Subject: SP-07-45, Caddis Creek Short Plat (3 Lots); Parcel #20-14-18040-0014  
Tony Schumacher, landowner/Encompass Engineering, authorized agent  
Access Via I-90 Exit 74 (W. Nelson Siding Road)

We have reviewed the proposed plat and have the following comments.

CADDIS CREEK SHORT PLAT

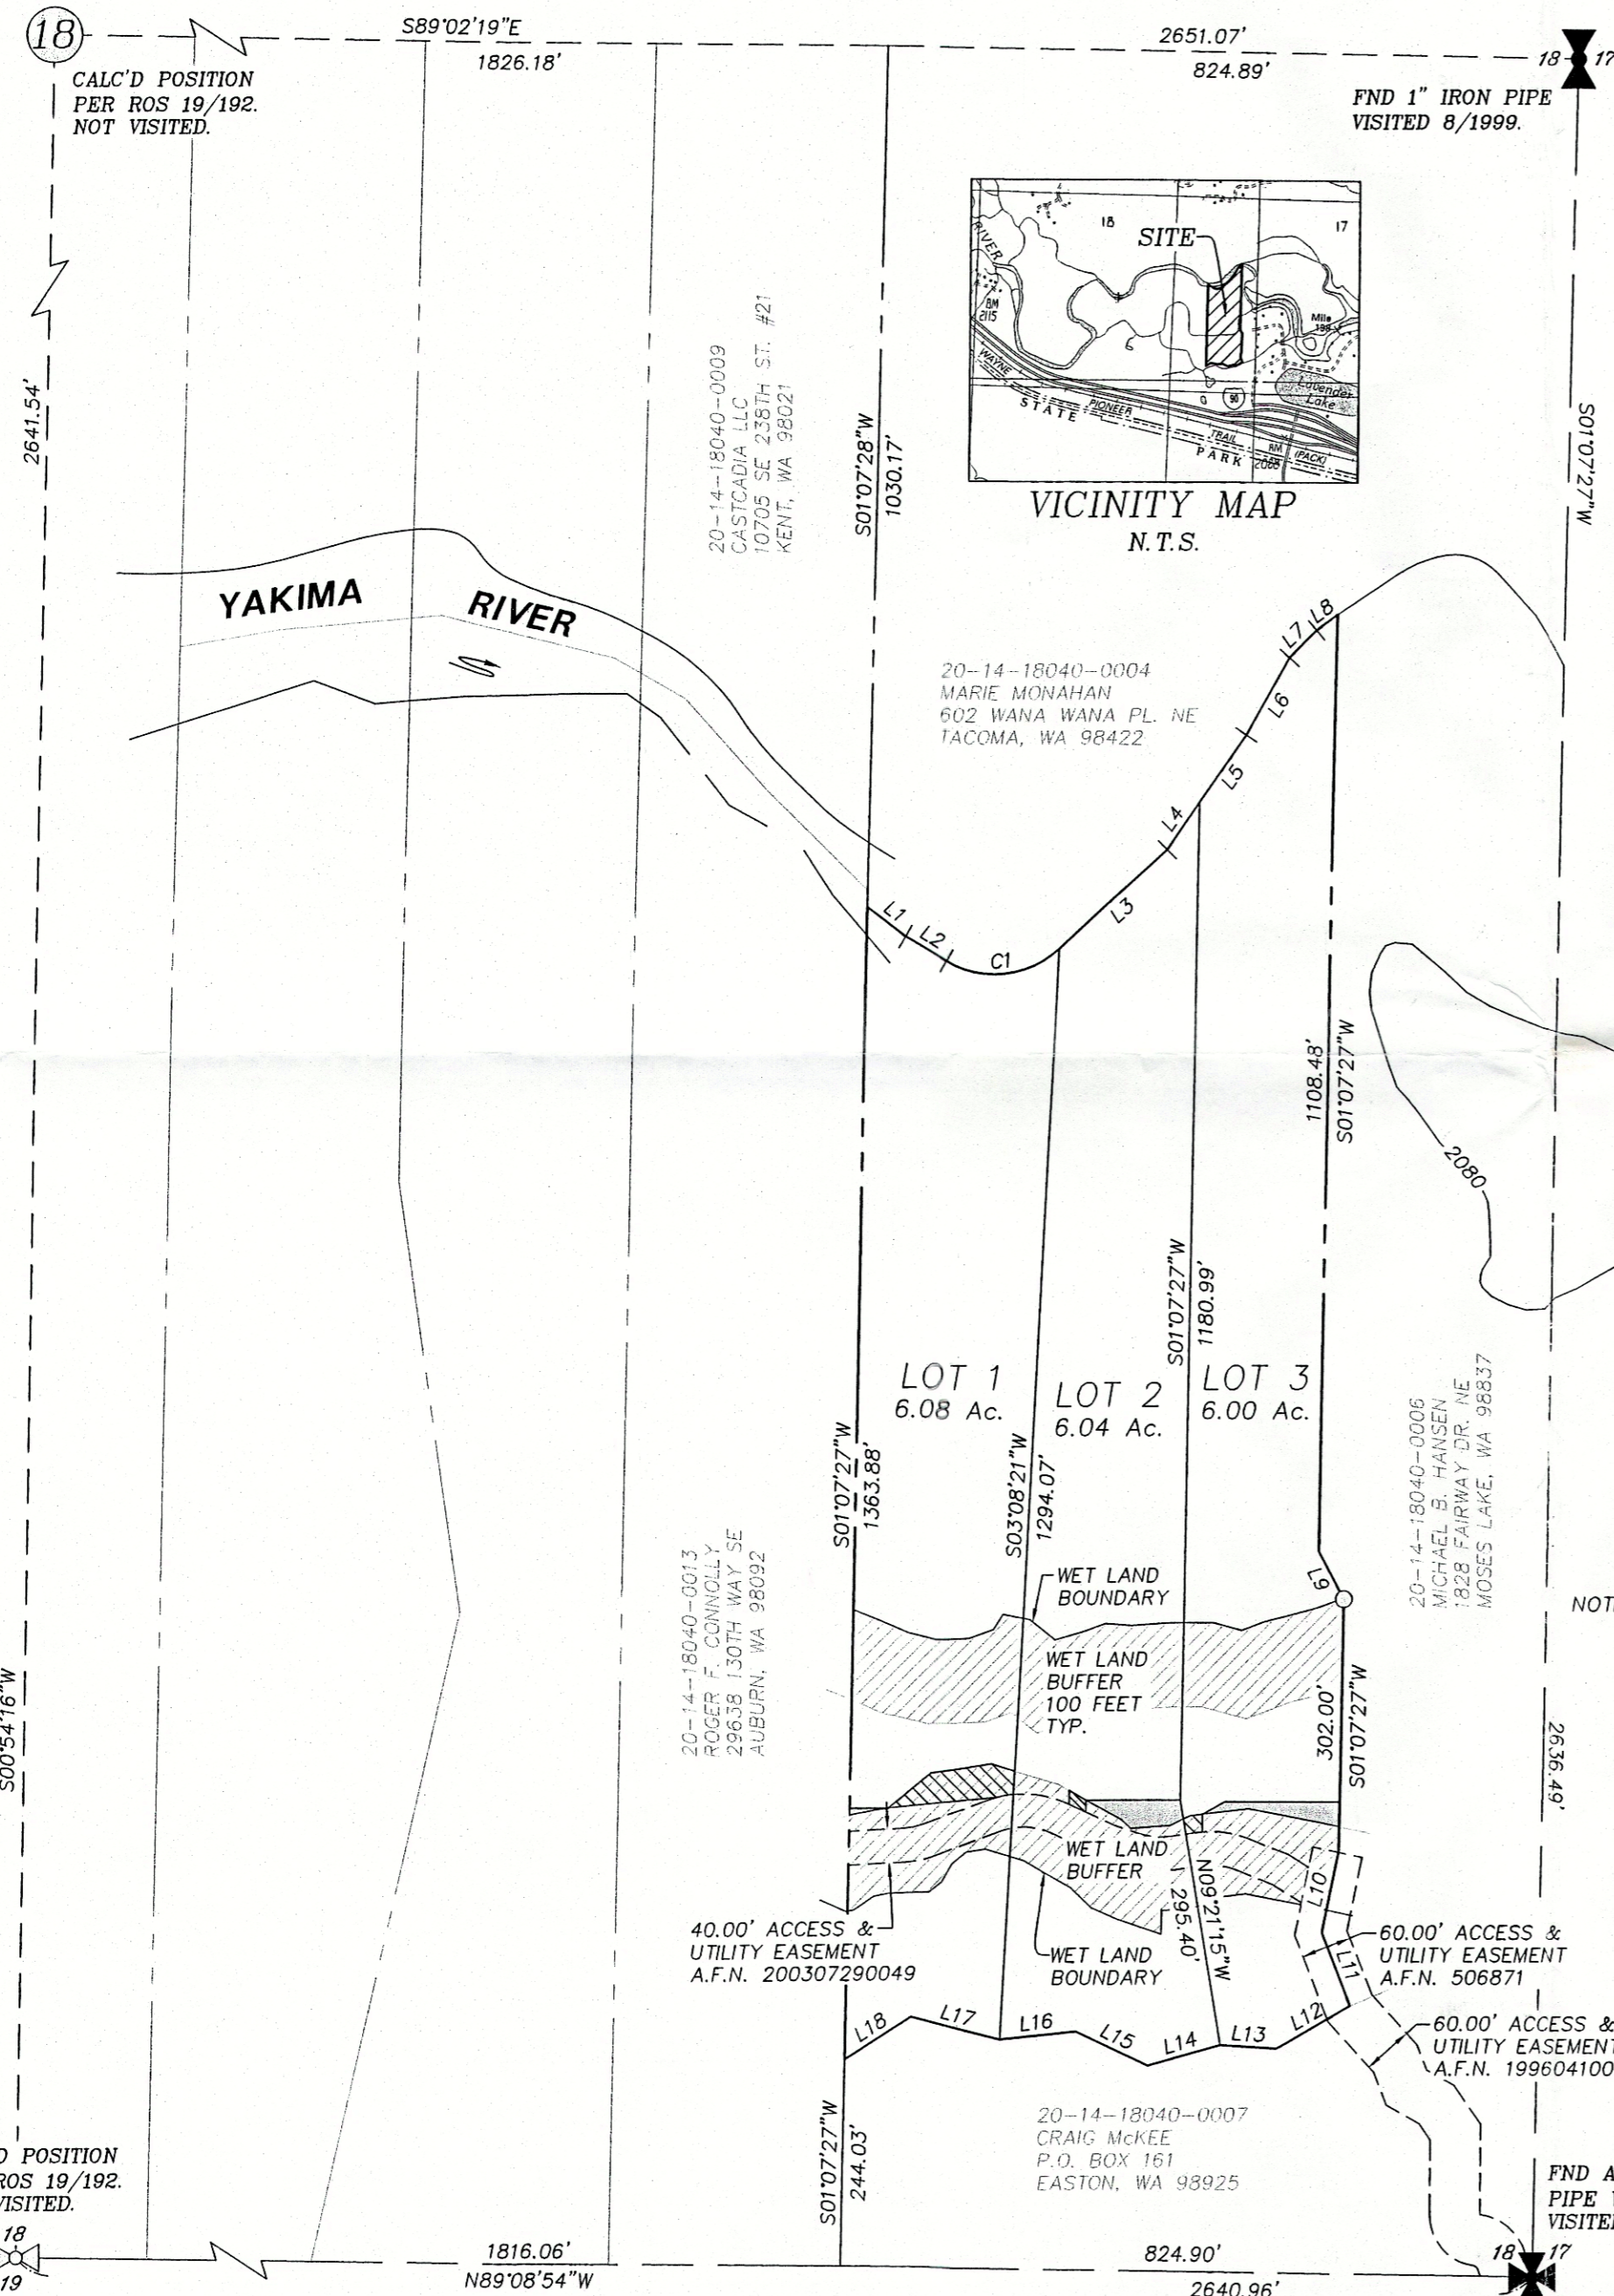
1. The plat site is adjacent to Interstate 90. I-90 is a fully-controlled limited access facility with a posted speed limit of 70 miles per hour. No direct access will be allowed to I-90.

Access to the plat area is via a frontage road connecting to the I-90 Exit 74 Interchange (W. Nelson Siding Road). The frontage road (Lavender Road) is within WSDOT jurisdiction, but is maintained on a low priority level. Similar to other locations within the upper County where development is occurring, WSDOT is not opposed to these developments. On the other hand, we are strongly opposed to WSDOT-maintained "frontage" roads being used as local access roads for expanding developments. Our responsibility is to preserve and maintain the interstate and state highway system, not to expend resources maintaining local access roads. We anticipate continued expansion of the residential land use in this area, and the frontage road is developing into a public road. As such, and as a condition of development approval, the frontage road must be brought up to County standards and the County must assume ownership of this road.
